CITY OF ALBUQUERQUE

RE: **ABCWUA Fence**
Tract 2-A, Bosque School
Grading and Drainage Plan
Engineer's Stamp Date: 3/4/18
Hydrology File: E12D015F

Based on the information provided in your submittal received on 3/8/18, the Grading Plan cannot be approved until the following are corrected:

RET WALL SKETCH ALONG NORTH PROPERTY LINE

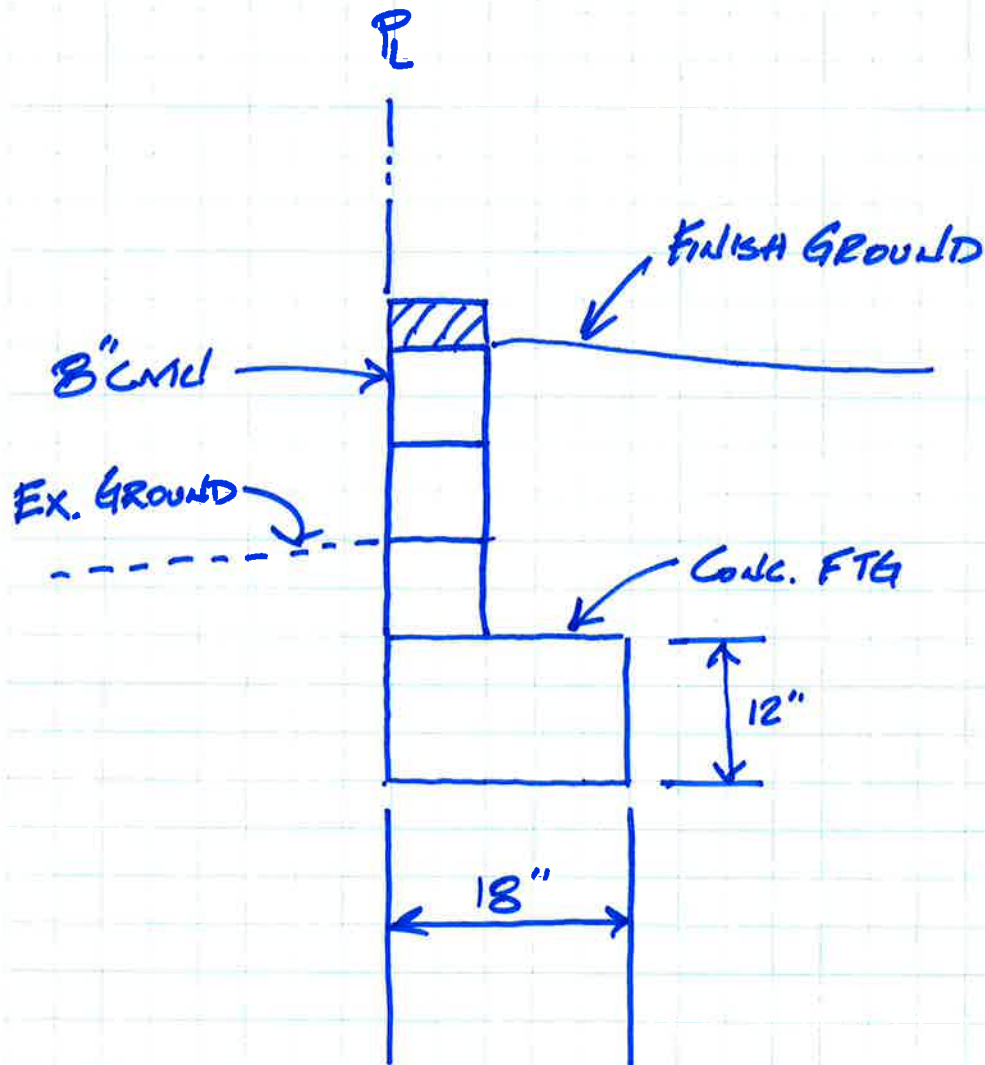
1. Please provide sections for the retaining walls. The retaining walls appear to straddle the property lines. If true, written permission will need to be obtained from the adjoining landowners for this encroachment.

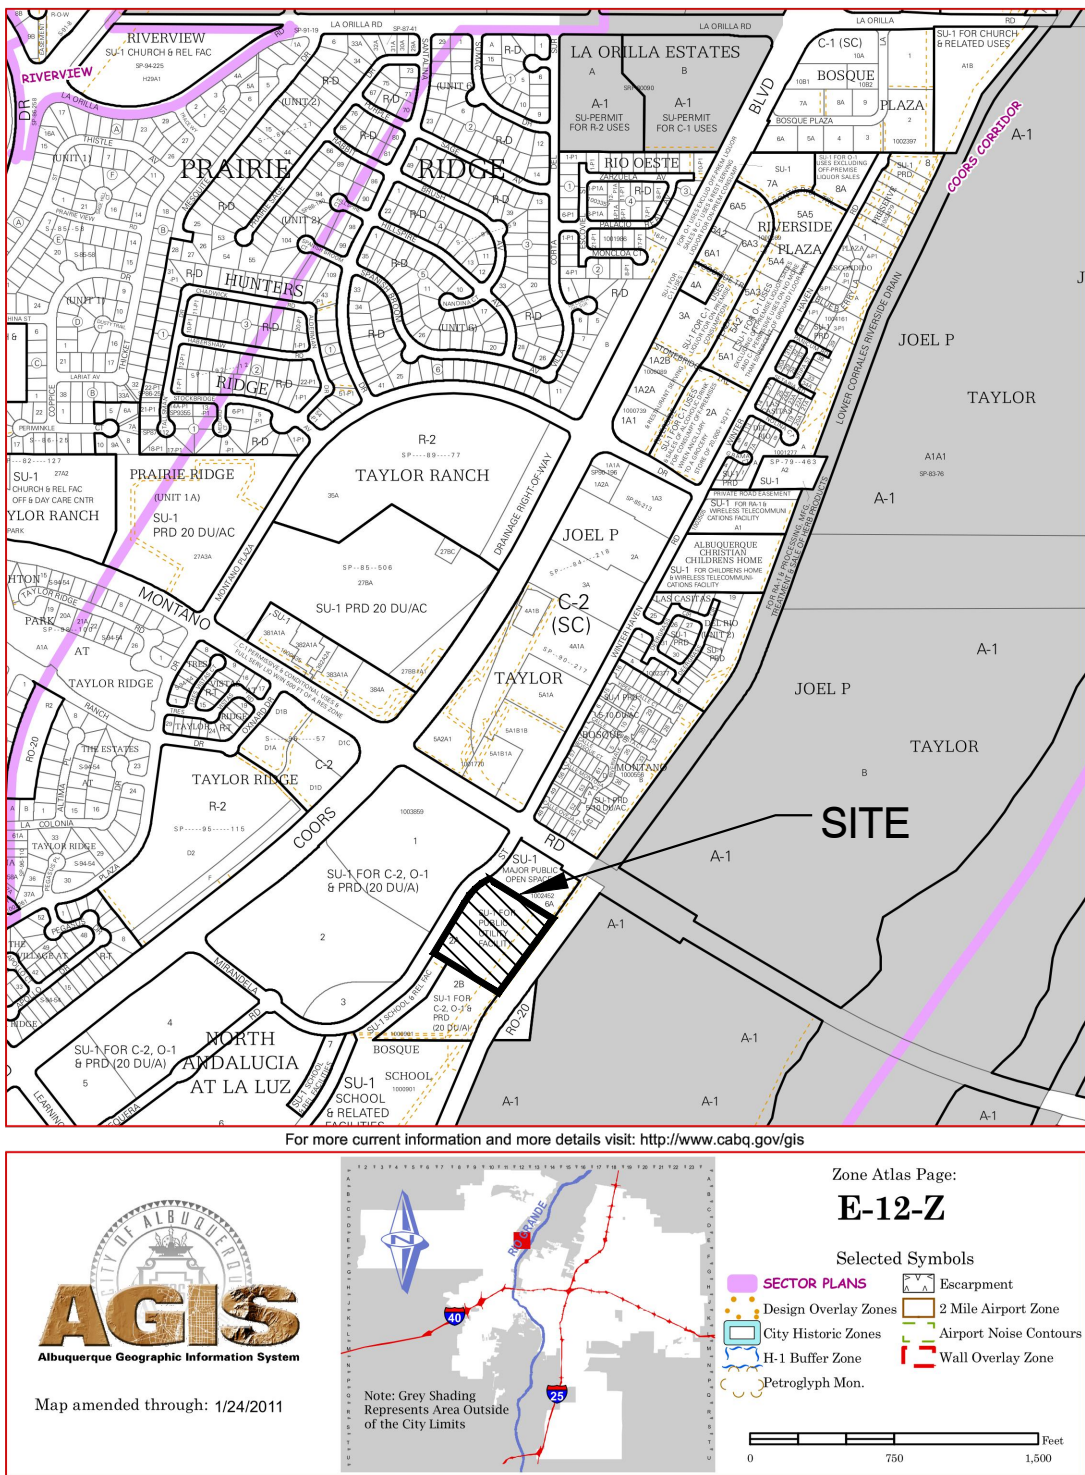
3. If permission for the retaining walls cannot be obtained, they will need to be inset from the property line such that the wall and its footer do not encroach on the neighboring property.

4. The grading near the northwest corner seems inconsistent with the desired effect. There seem to be some unintended depressions and cuts as though Civil3D generated the surface with several bad points. Please look at this area and call me if you have questions.

5. Please add a note where the pond crosses the pond to the effect of: "No grading or filling of the pond is allowed with this fence construction".
6. Add a note on the plan that no work shall be allowed in the public ROW without an Excavation Permit.
